Town & Country Planning Act 1990 (as amended)
Town and Country Planning (Development Management Procedure) (England) Order 2015
Approval of details reserved by condition No. 11 imposed on planning reference R/269/15/PL
relating to scheme for disposal of surface water drainage
Fleur De Lis Station Road, Rustington,

Decision:

Arun District Council have decided to **REFUSE details reserved by condition for the following reasons:**

DRAINAGE LAYOUT				
Scale 1:125	Paper Size A1	Date JUNE 2017	Drawn By JH	Checked By CH
Project No. RRL012		Drawing No. 505		Revision P3

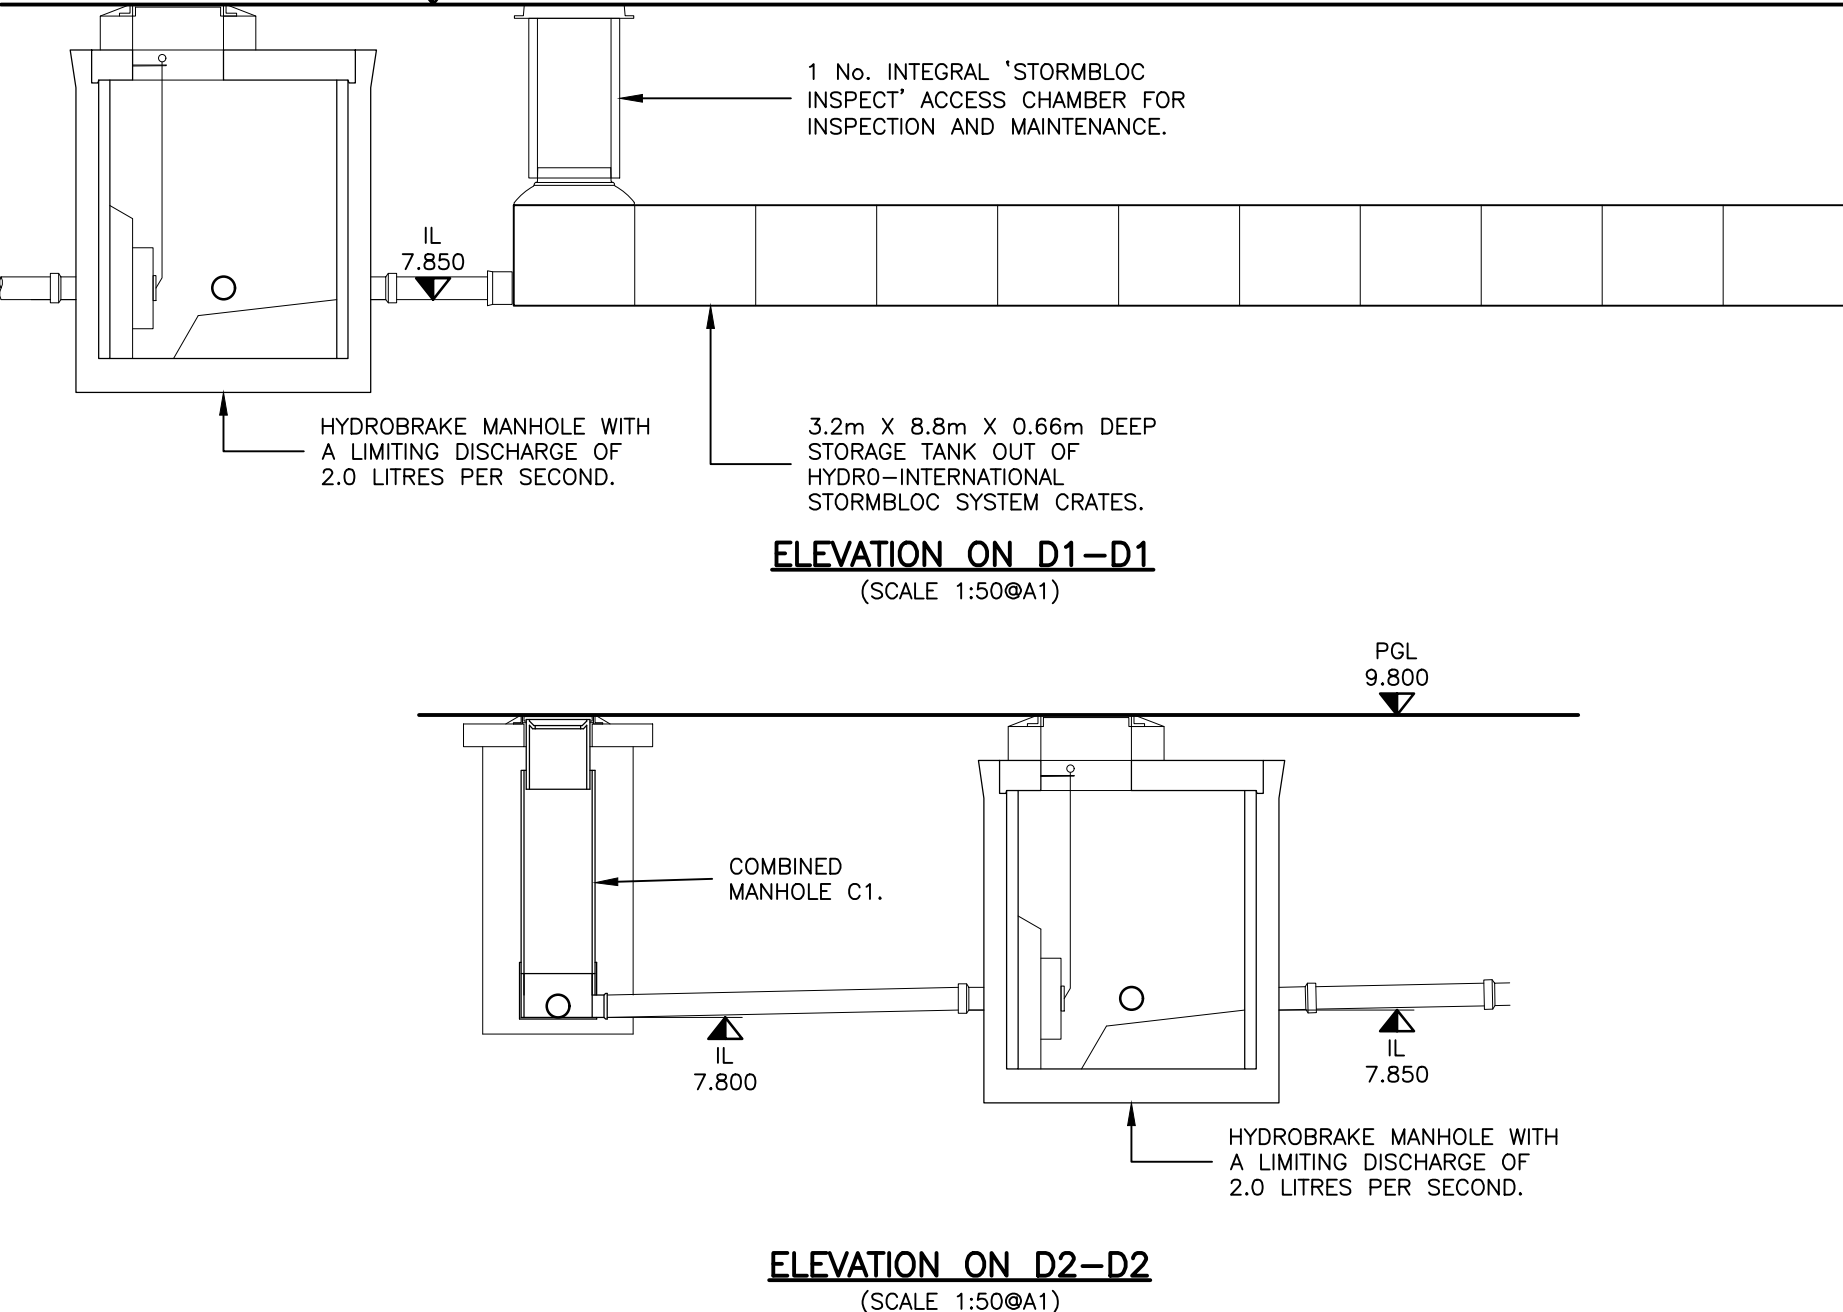
The information submitted is not adequate to discharge the condition.

No proof has been submitted to demonstrate that groundwater monitoring and winter percolation tests in accordance with BRE365 have been completed. Discharge to the foul sewer is the last option.

Test results need to be provided before our engineers can review the proposals further.

It would also be beneficial to know where surface water from the previous building went to.
docdeci
